Date: 05-Jun-2023  
Our Ref: 2023/91210

**Discharge condition 6 (noise barriers), 7 (finishes colour of plant and dimensions of pump and chiller ) on previous permission 2021/92779 for erection of plant deck consisting of new heating, ventilation and air conditioning system (HVAC) with associated works  
Thornton And Ross Ltd, Manchester Road, Linthwaite, Huddersfield, HD7 5QH  
Application Number: 2023/91210**

I write with reference to your application to discharge the conditions for the above development as submitted on 21-Apr-2023. This letter concludes that, at this time, condition 7 is approved and further information is required in support of condition 6.

Document Number
AAA5581-RPS-XX-XX-DR-A-0010

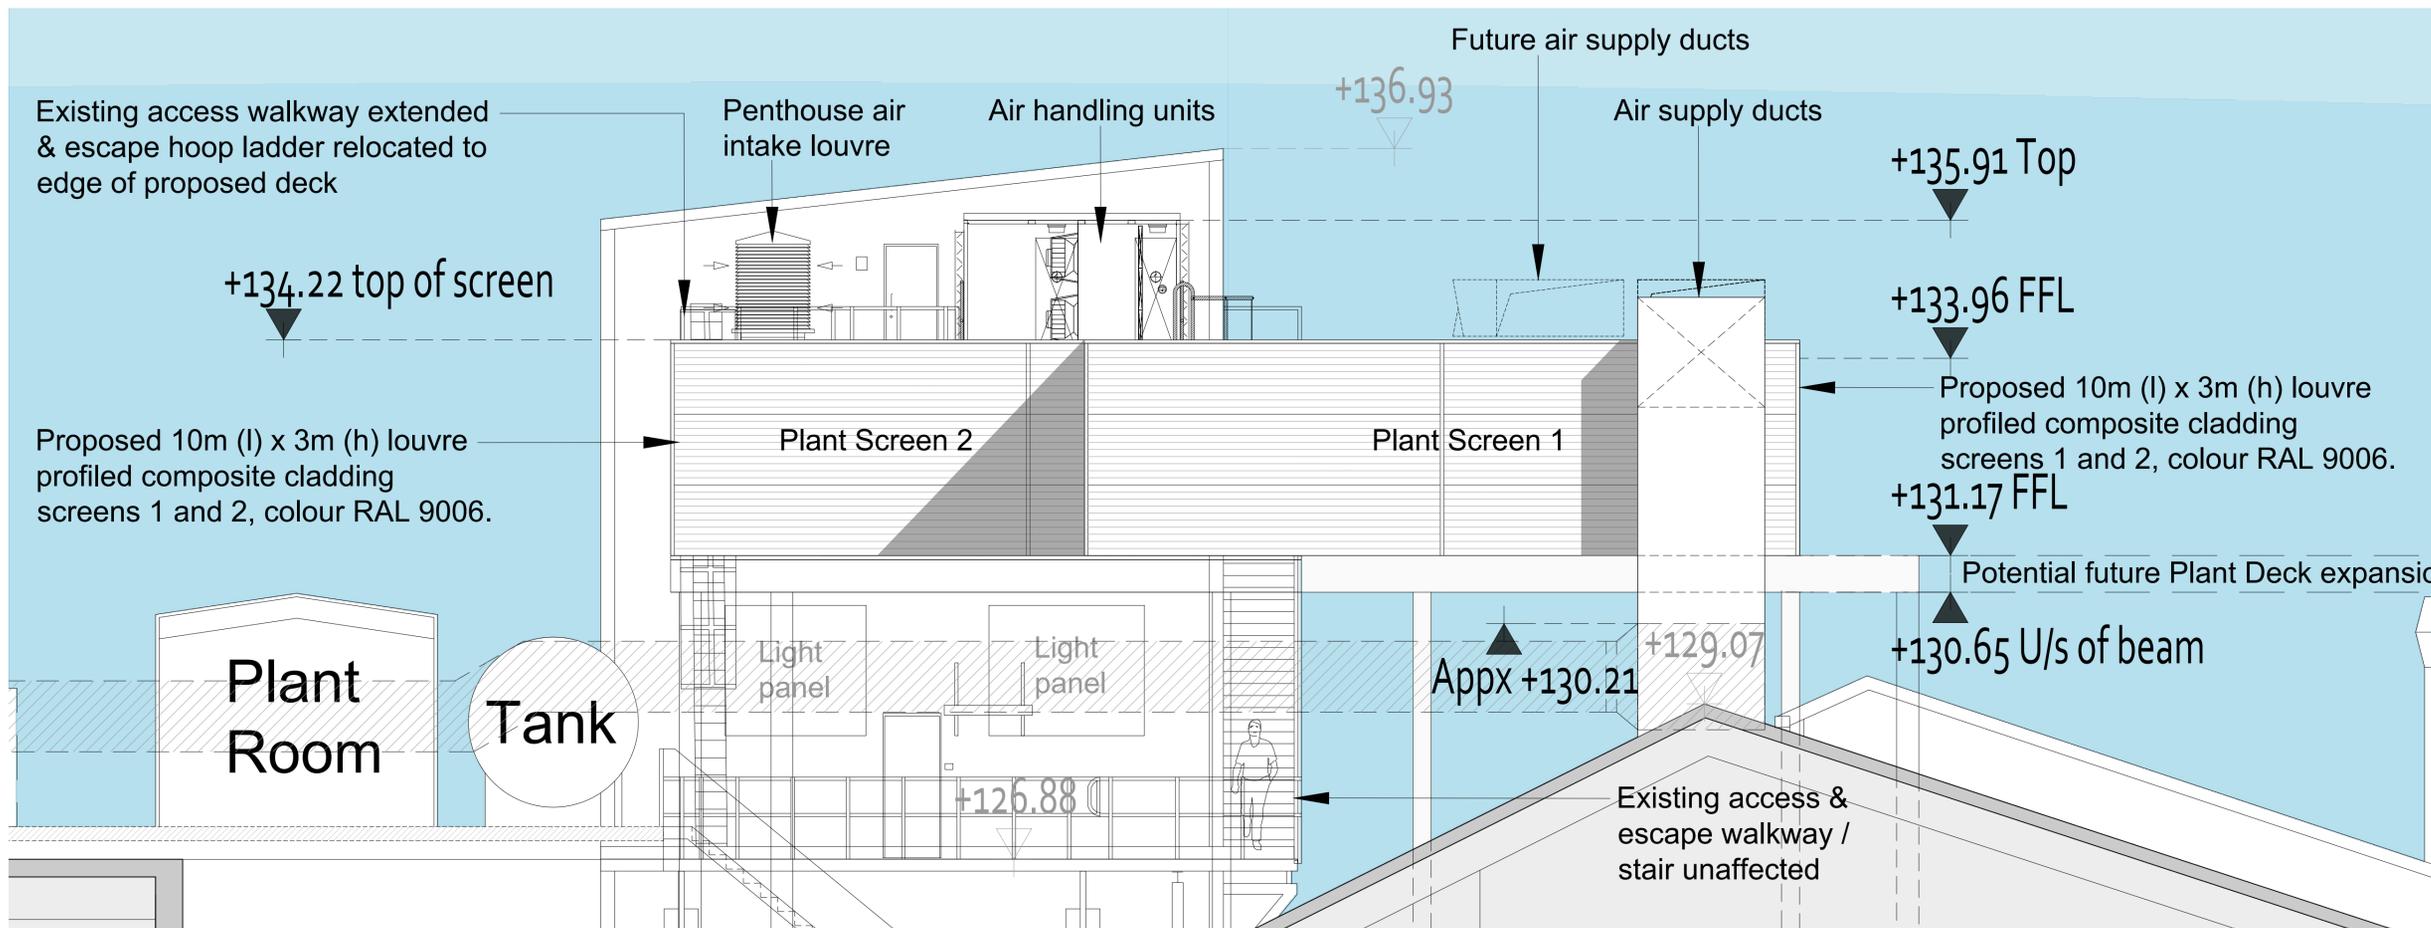
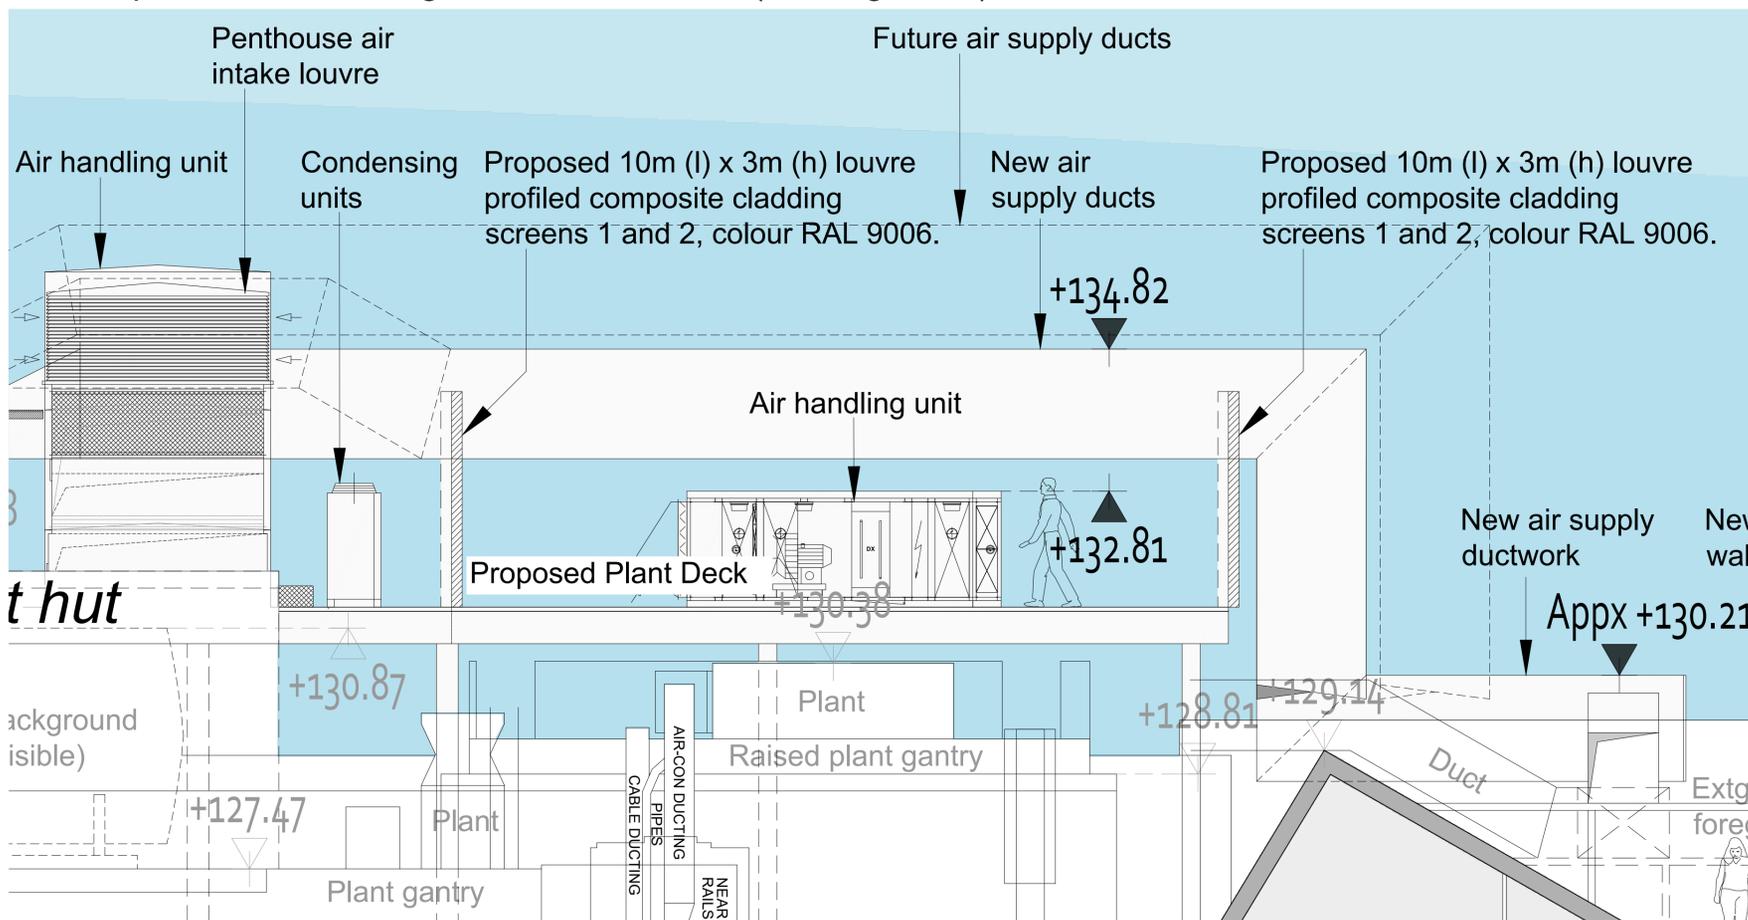
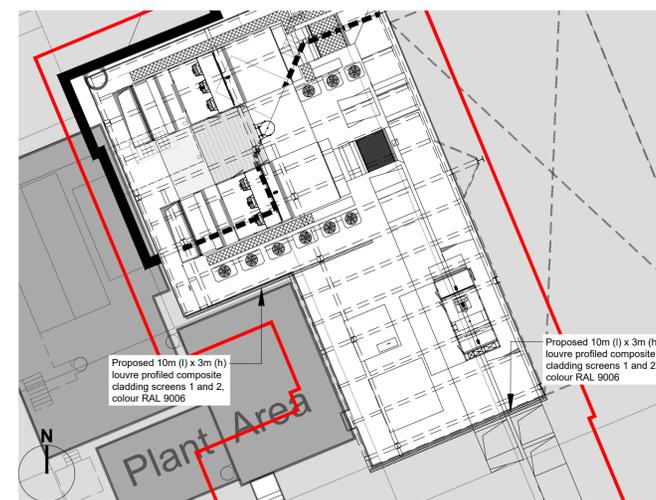
At this time, it is not possible to discharge the requirements of condition 6 as the acoustic specification of the noise barriers is not known. The other elements submitted (design details of the noise barriers, including location, elevations, colour, materials) will not be assessed until final details of the acoustic specification are submitted.

You are invited to submit an up-to-date NIA (addendum) to address the uncertainty in the original and submitted NIA under this application (ref 2023/91210). If this results in amendments to the submitted proposed elevations and sectional elevation drawing ref AAA5581-RPS-XX-XX-DR-A-0010 , this should form part of the amended submission.
